WSSC Commentary on the Proposed Lyminster By-pass Acoustic Fencing

- a. Discharge of Condition 36, Lyminster Bypass – Issue No. 2, 25th August 2017 (i.e. the section to the north of the A259 / the 'southern bypass').
- b. Discharge of Condition 18, Fitzalan Link Road, Noise Assessment – Issue No. 3, 19th August 2019* (i.e. the section to the south of the A259 / the 'Fitzalan Link').

**Drawing Title / Scenario:
Acoustic Fence Detail**

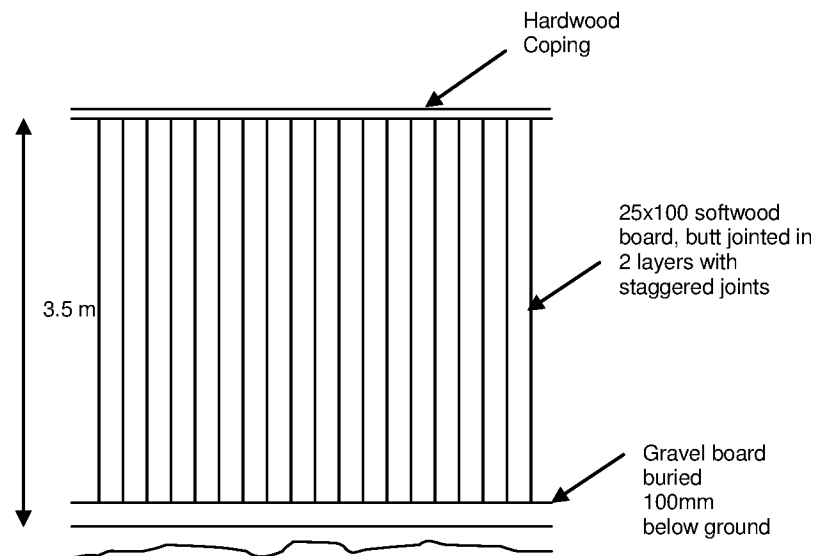
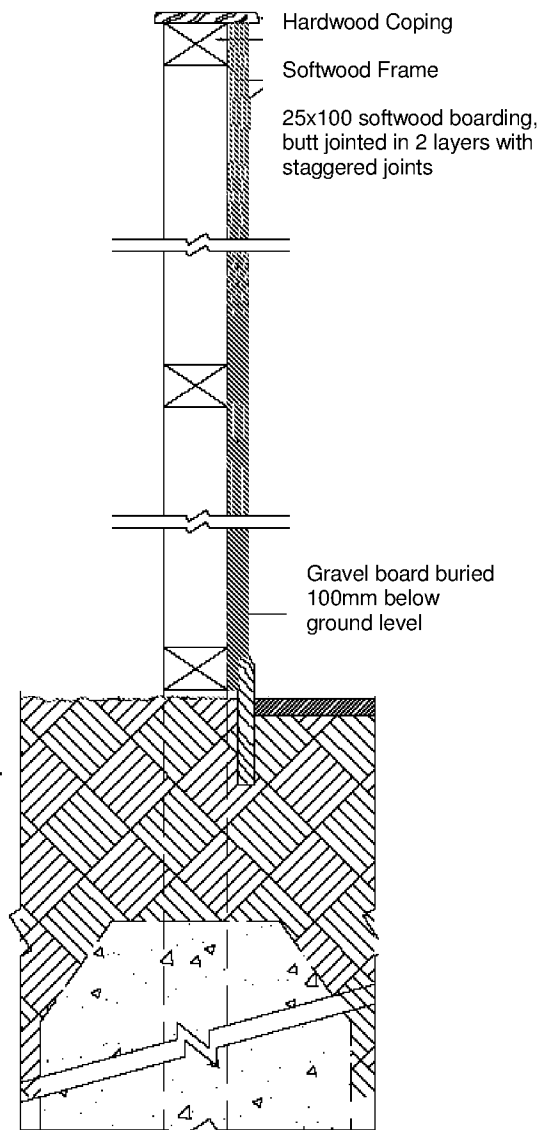
- a. Section to the north of the A259 (the 2017 Condition 36 report) shows a timber framed fence with 'vertical 25x100mm softwood [timber panelling], butt jointed in 2 layers with staggered joints'.
- b. Section to the south of the A259 (the 2019 Condition 19 report) shows a steel framed fence with vertical '96mm steel / aluminium panels'.

- a. Section to the north of the A259 (the 2017 Condition 36 report) shows timber reflective type.
- b. Section to the south of the A259 (the 2019 Condition 19 report) shows vertical steel panels that could be interpreted as either reflective or absorptive.

For the reasons outlined above decisions regarding the proposed acoustic fences should be taken with a holistic view of form vs function. A metallic fence will provide far longer acoustic and non-acoustic lifespans (up to 60 years), and therefore provide longer term savings, but subjectively it doesn't have the aesthetic appeal of a timber alternative.

A 'weathering steel' acoustic fence is the preferred solution of the WSCC Structures Department that not only meets the acoustic and non-acoustic criteria, but also has an aesthetic appeal. The following section looks at potential options.
